## **Deadline 8 Written Submission – SZC a deliverable project?**

Ian Galloway #20025801

In this connection, I have not received a response from the Applicant. Nor have I been able to identify anything other than a wholly inadequate Plate 2.1 (Assumed construction programme) within the Applicants document - 6.3, Volume 2 Main Development Site, Chapter 3 Description of Construction, Appendix 3D of the Environmental Statement [Rep7-015], published in September 2021.

Plate 2.1: Phasing Schedule

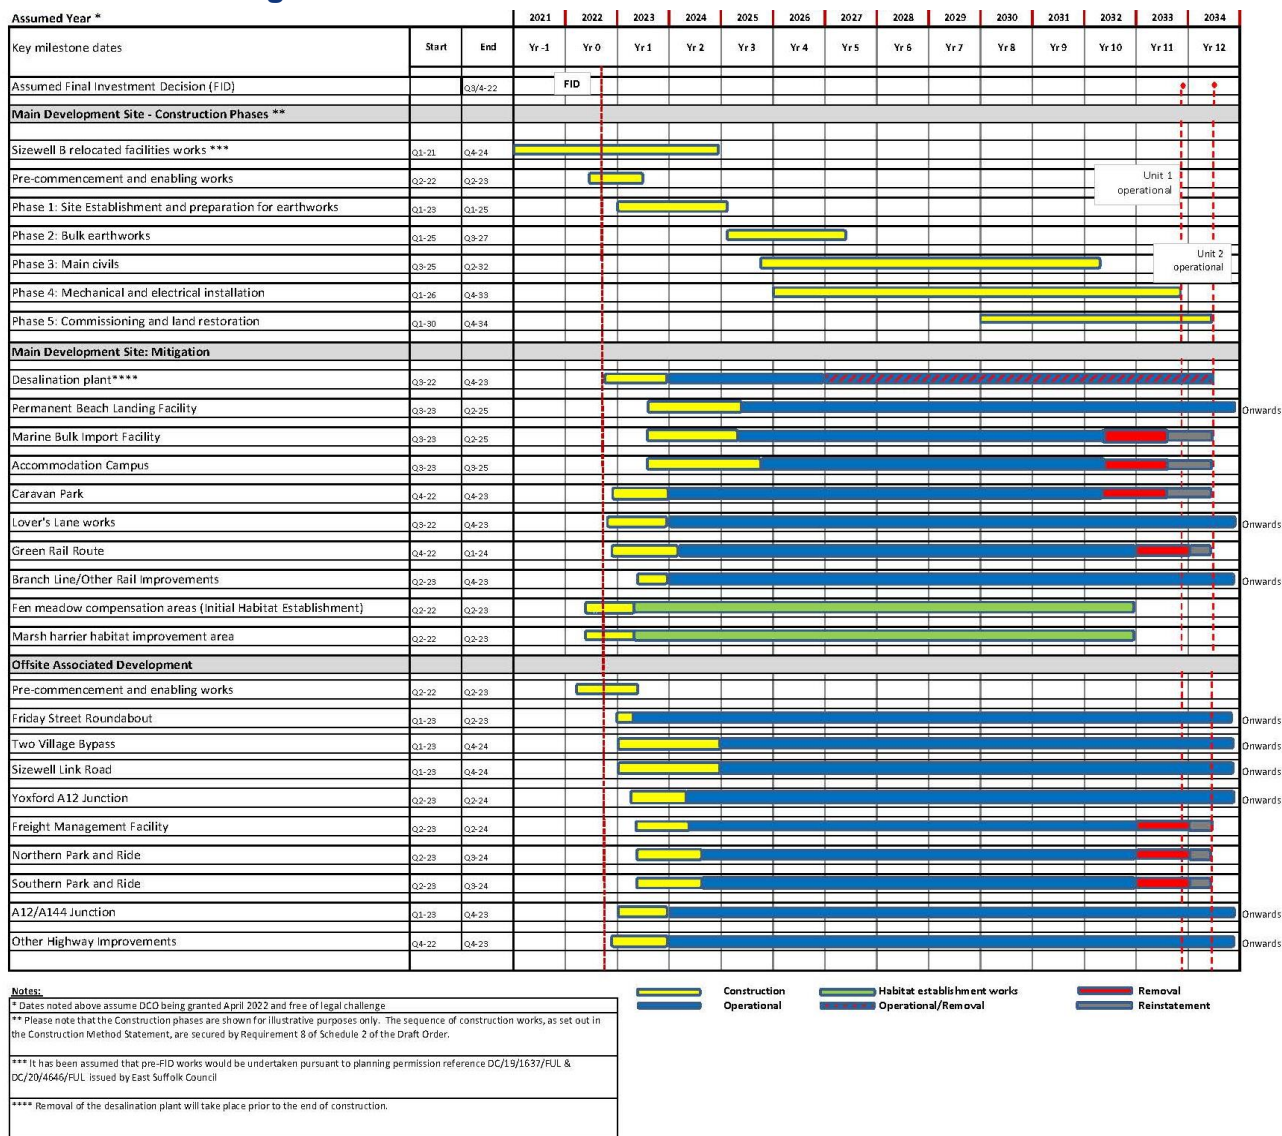
To illustrate the inadequacy of; Plate 2.1, the continuing opacity of the Applicants project plans and in the absence of being able to discover anything more substantial, how should an interested party easily discern: when the proposed 2 Village Bypass; and Sizewell Link Road both commence and conclude construction simultaneously, exactly how 'back-fill transfers' to the Main Development Site will be routed from the former development through the latter (whilst it performs the expressed role of 'haul-road' for circa 70,000 HGV transfers)?

Returning to the critical issue of the Applicants Project Planning and the detail contained therein, as stated in my previous submission at Deadline 7, it is essential that the Applicant place in the public domain their Project Plan, identifying; the overall project architecture, a sensible and detailed portrayal of the 'key milestones' for the project (possibly at L2/L3), the projects singular critical path, a detailed schedule of dependencies and interdependencies both; within discrete work-streams/disciplines and betwixt work-streams/disciplines and linked through a sensible project resource plan, reflecting the manpower and potential traffic movements on any particular day, on any specific route or road.

Moreover, where there may be significant changes in methodology throughout an activity (i.e. the routing of back-fill transfers from the 2 village bypass/Yoxford Junction, via the B1122 potentially migrating to the proposed SLR), the target transition window(s) should be identified with any inter-dependencies.
